From: Rush, Rachel (DFW) <Rachel.Rush@dfw.wa.gov>
Sent: Wednesday, July 22, 2026 11:25 AM
To: Bradley Gasawski
Cc: Jamey Ayling
Subject: RE: SX-26-00015 WDFW - Vault Toilet Location

From: Bradley Gasawski <bradley.gasawski@co.kittitas.wa.us>
Sent: Wednesday, July 22, 2026 11:12 AM
To: Rush, Rachel (DFW) <Rachel.Rush@dfw.wa.gov>
Cc: Jamey Ayling <jamey.ayling@co.kittitas.wa.us>
Subject: SX-26-00015 WDFW - Vault Toilet Location

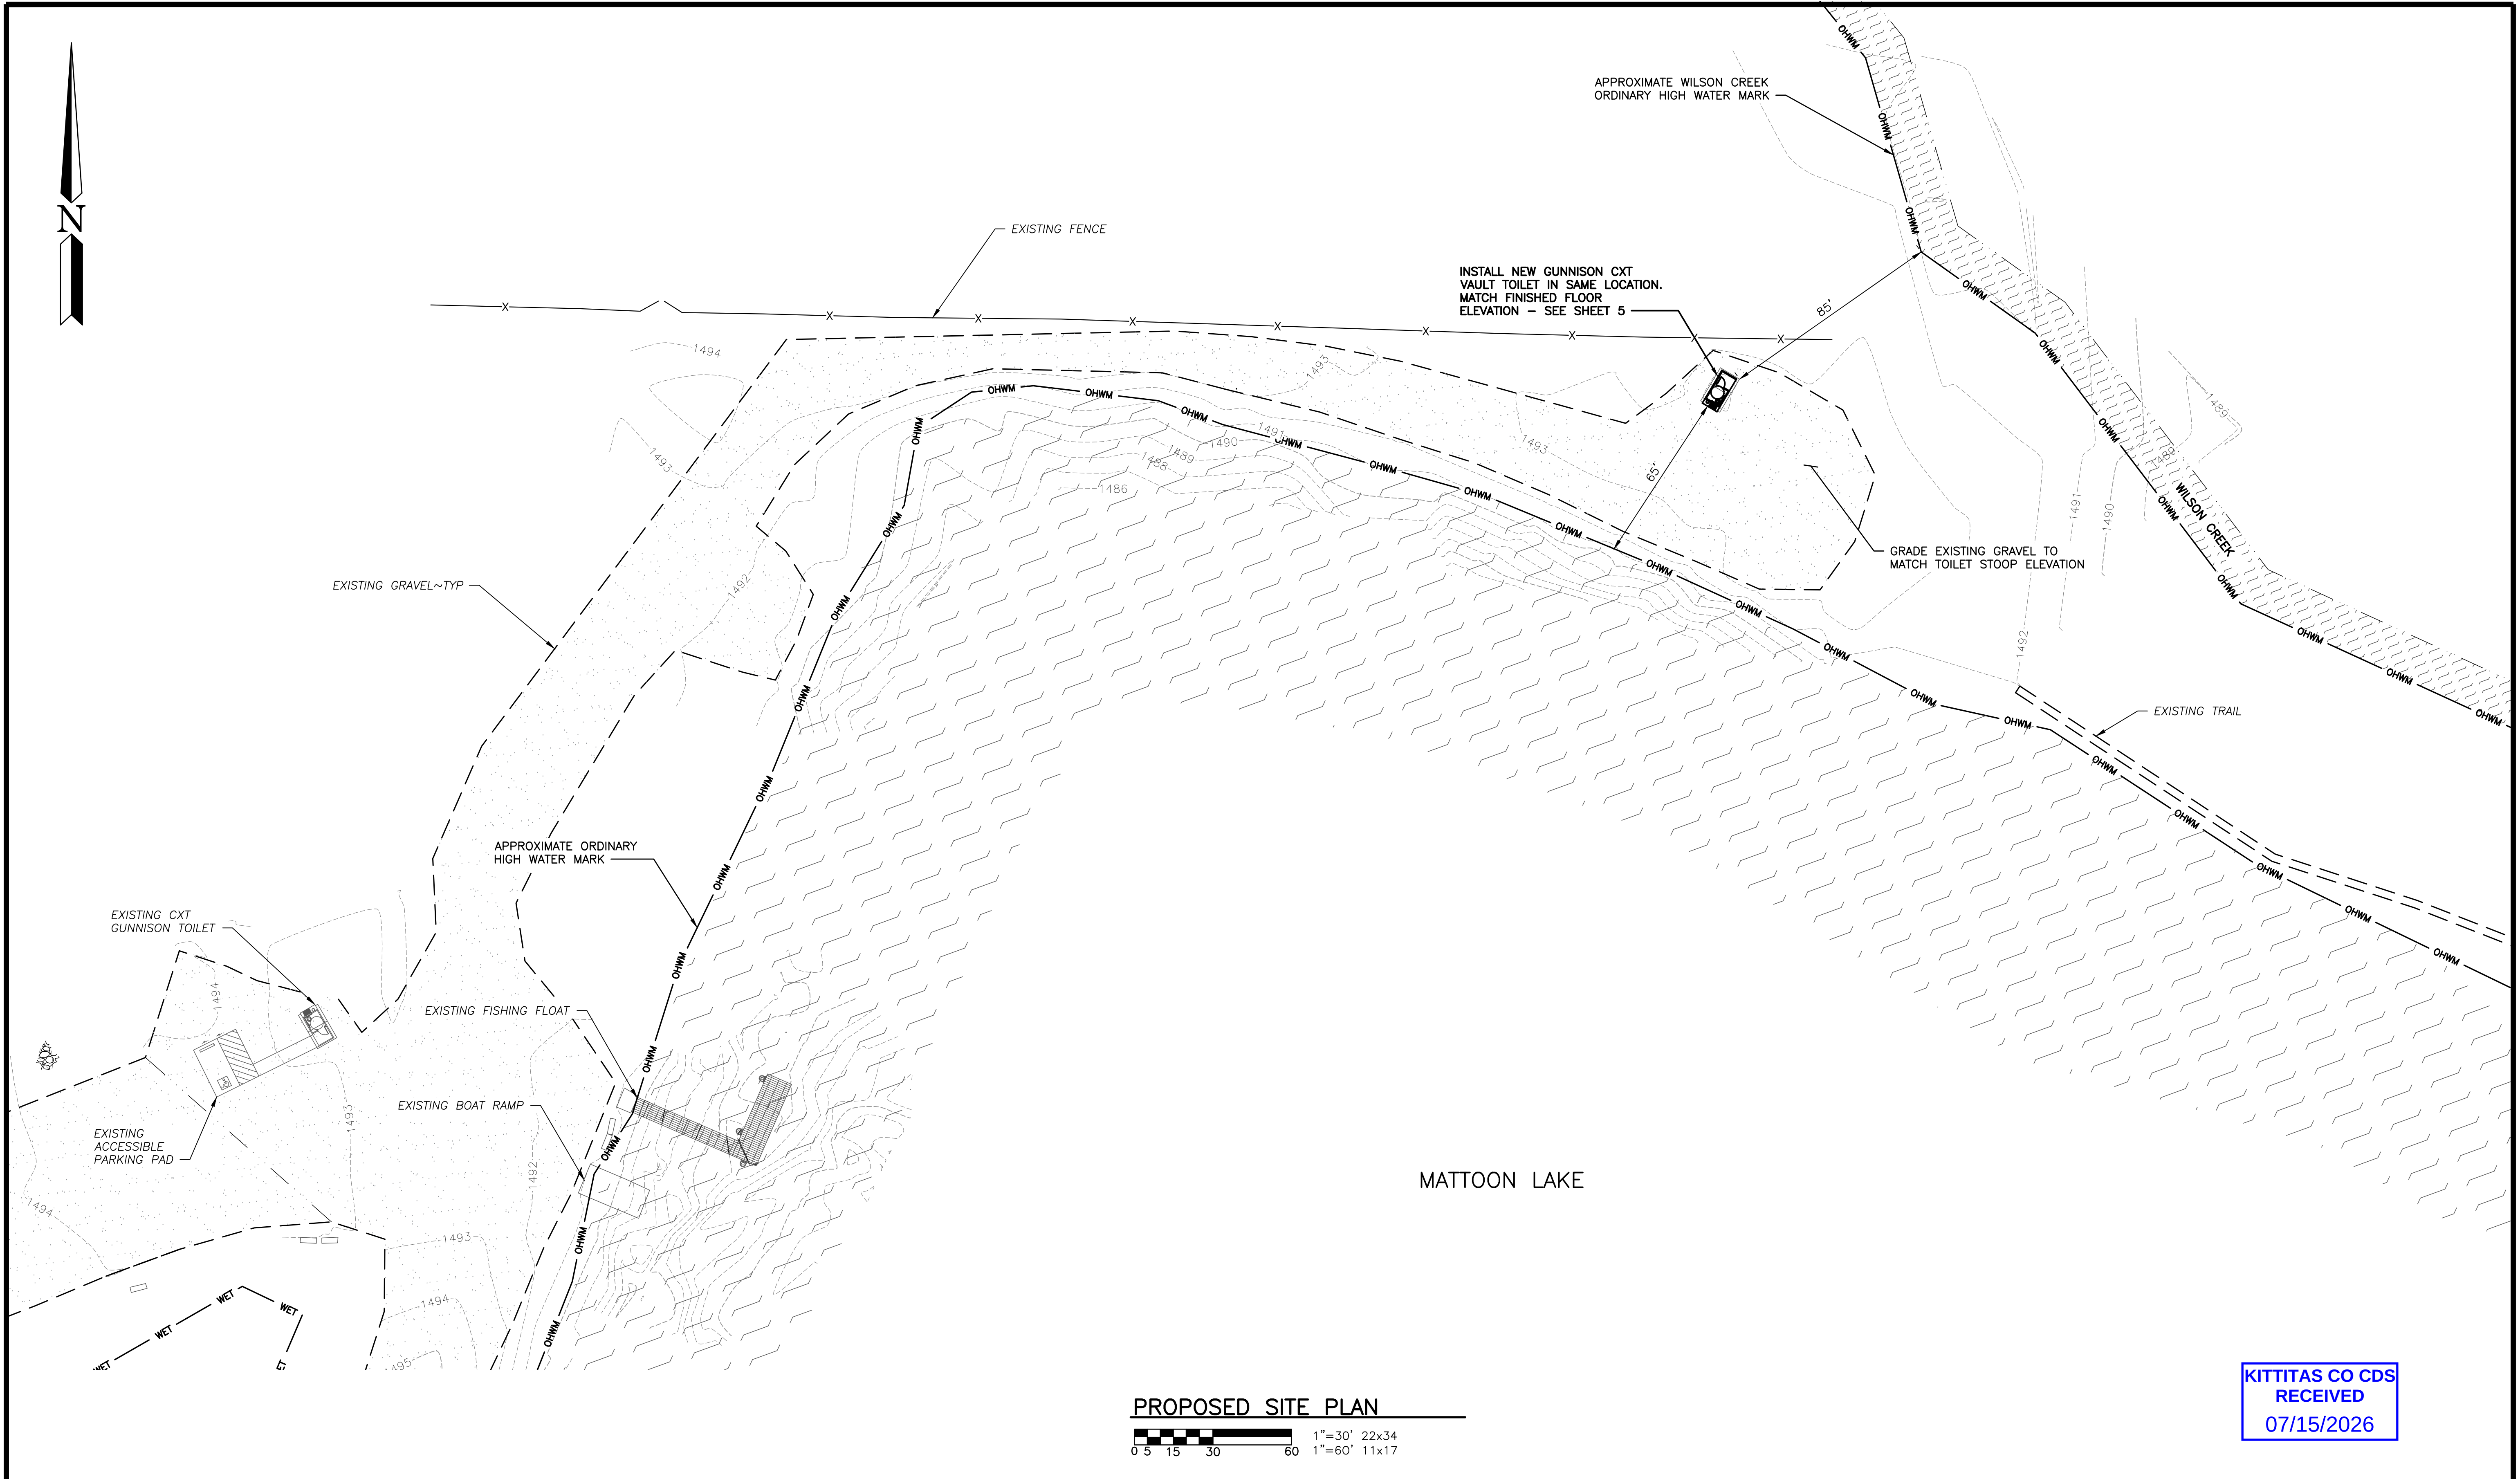
What is the setback distance of the vault toilet from the property line? The side yard setback is 15' for the Urban Residential zone.

The vault toilet is approximately 22 feet from the property boundary.
